Application No. 2011/1295, Honeywell Demonstration Houses, Barnsley College.

Please find enclosed the drawings listed below to substitute those originally lodged via the planning portal, application reference number PP01651135, on October 13th in respect to the application for full planning consent for the erection of 10no. Demonstration houses at Honeywell site Barnsley College.

0022_A_2001 Rev C	Proposed General Arrangement Site Layout
0022_A_2100 Rev E	Proposed General Arrangement Ground Floor Plan
0022_A_2101 Rev E	Proposed General Arrangement First Floor Plan
0022_A_2102 Rev D	Proposed General Arrangement Second Floor Plan
0022_A_2103 Rev A	Roof Plan
0022_A_3000 Rev C	Proposed GA Elevations
0022_A_4000 Rev C	Site Cross Sections
0022_A_4001 Rev A	Proposed GA Sections

Drawing
Proposed General Arrangement
Ground Floor Plan

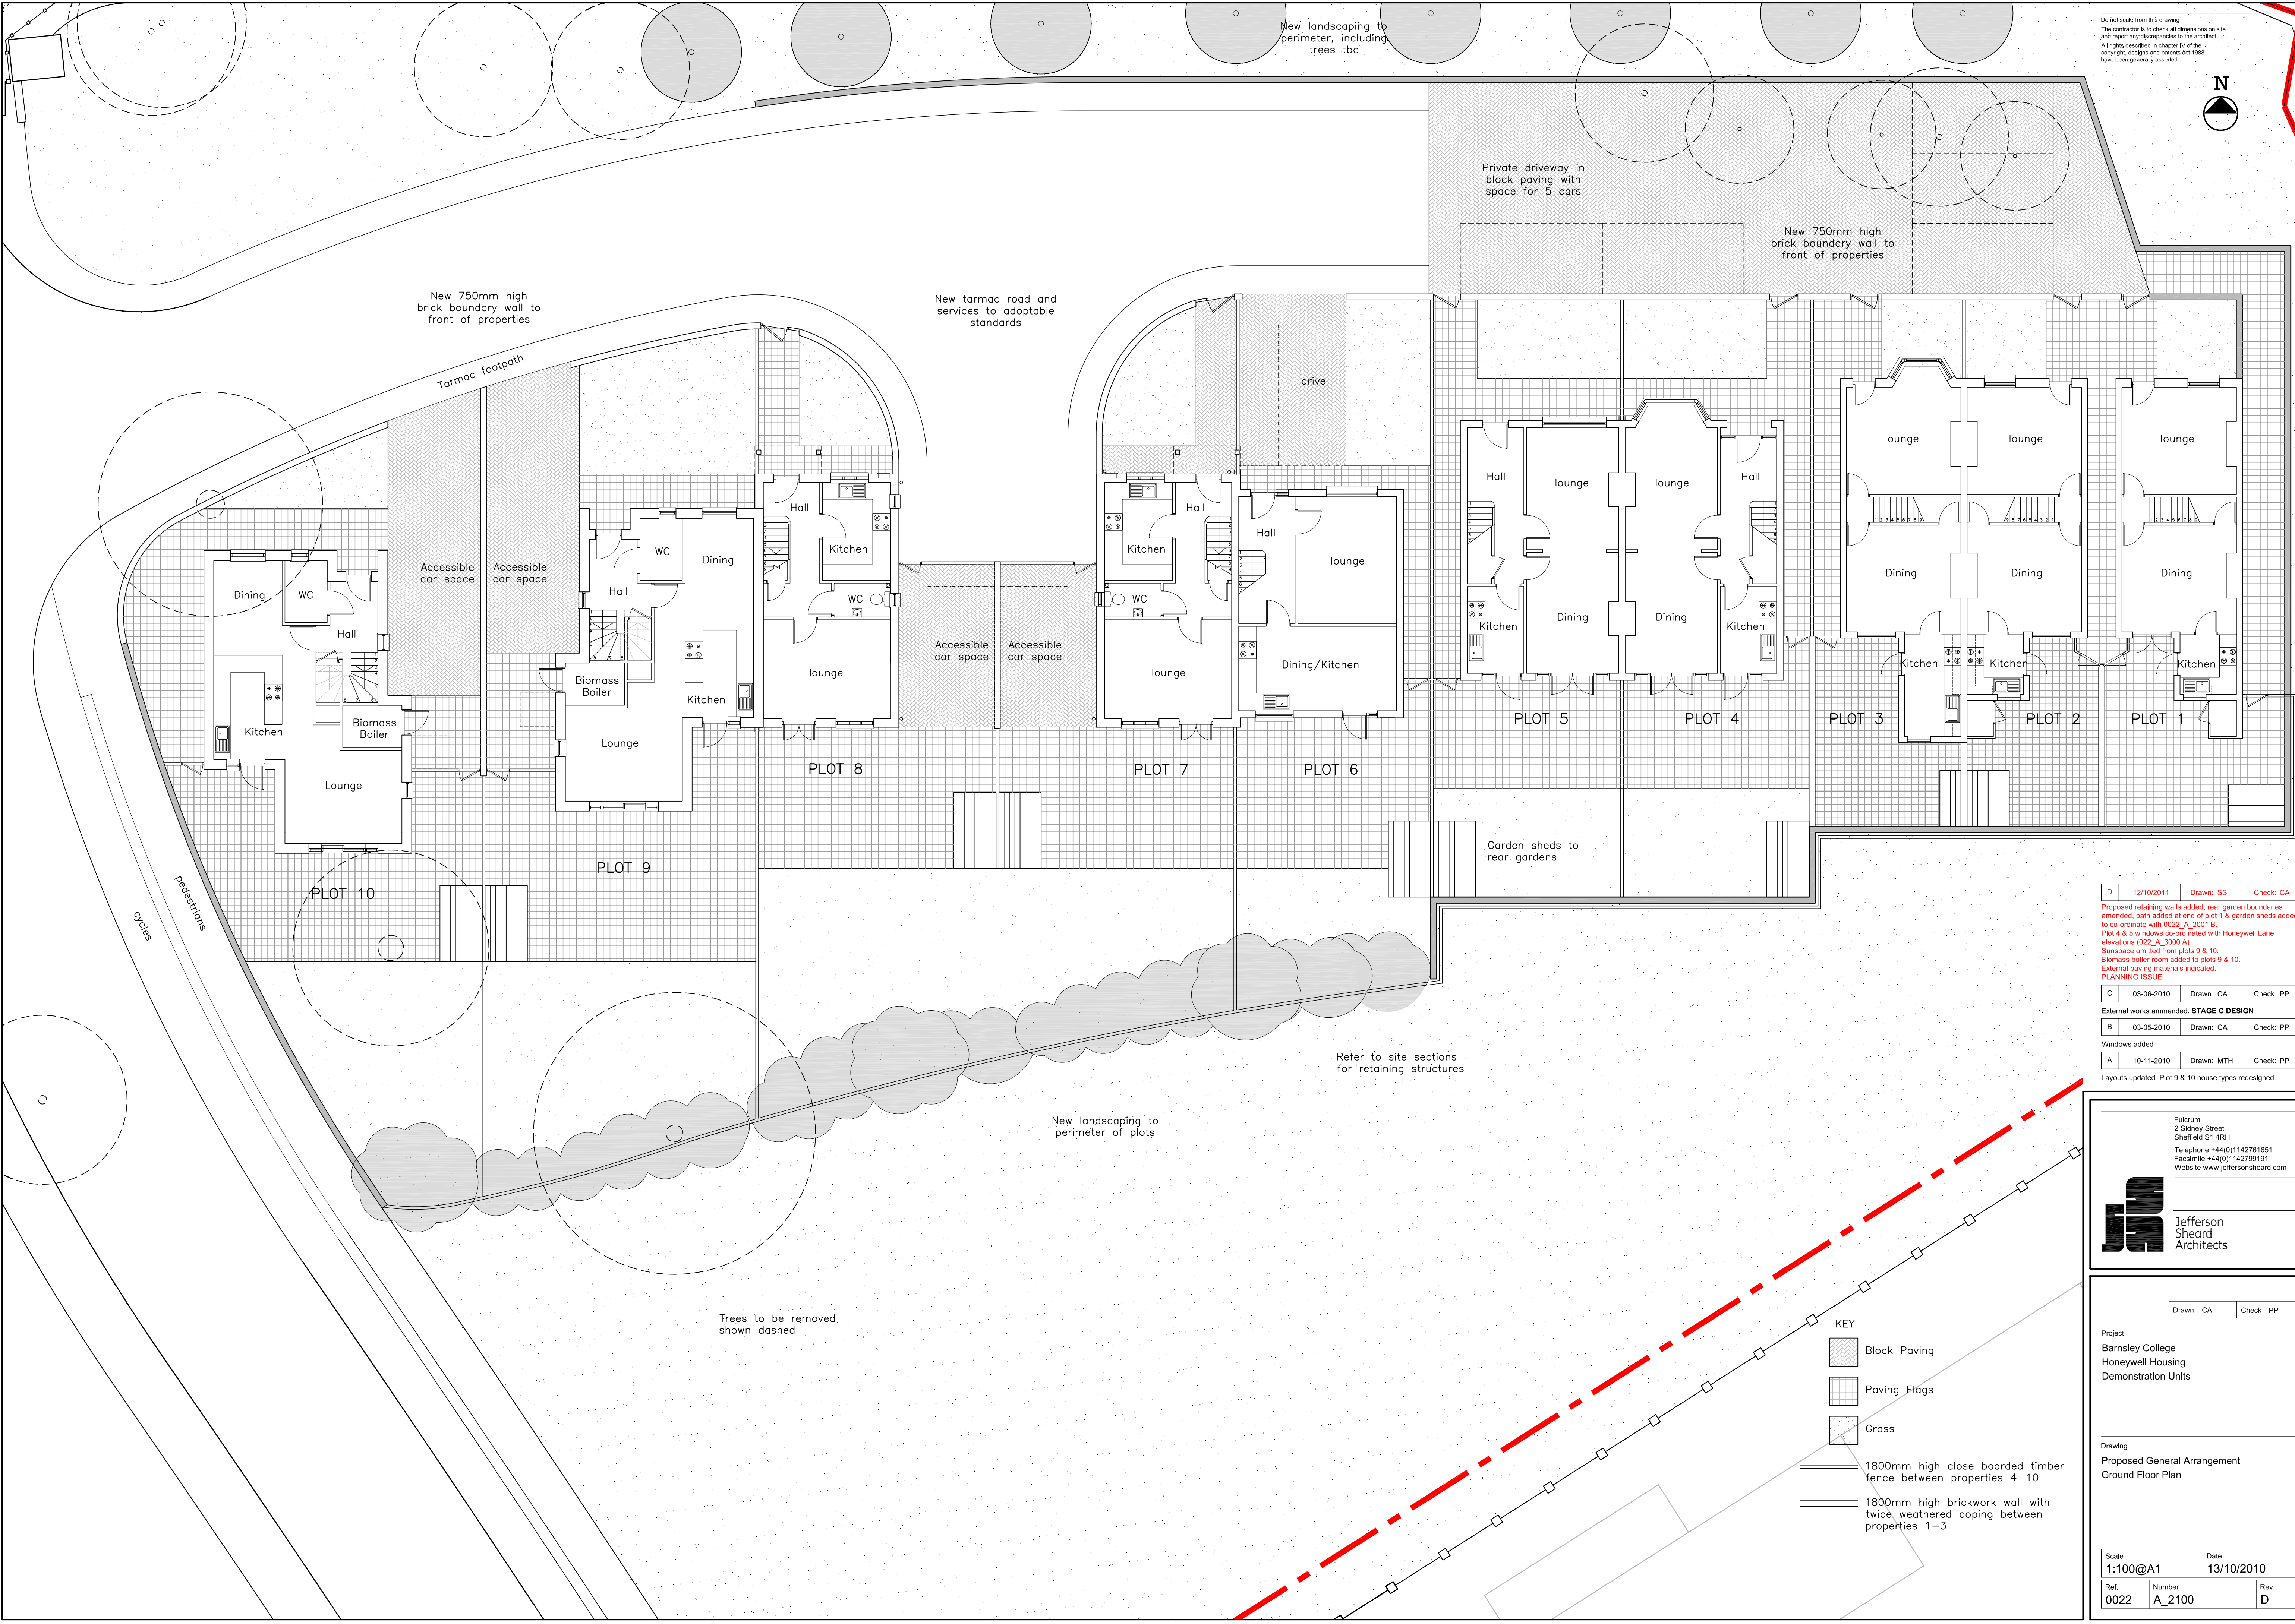
- Alignment of the chimney to plots 9 and 10 elevation
- Provision of 'Juliette' balconies to plots 9 and 10 elevation
- East elevation to plot 9 amended to stone in lieu of render
- Plan adjustments to alignment of security fencing to rear and side of properties following comments from the Police Architectural Liaison Officer
- Co-ordination of site levels
- PV array added to south facing roof of plot 6
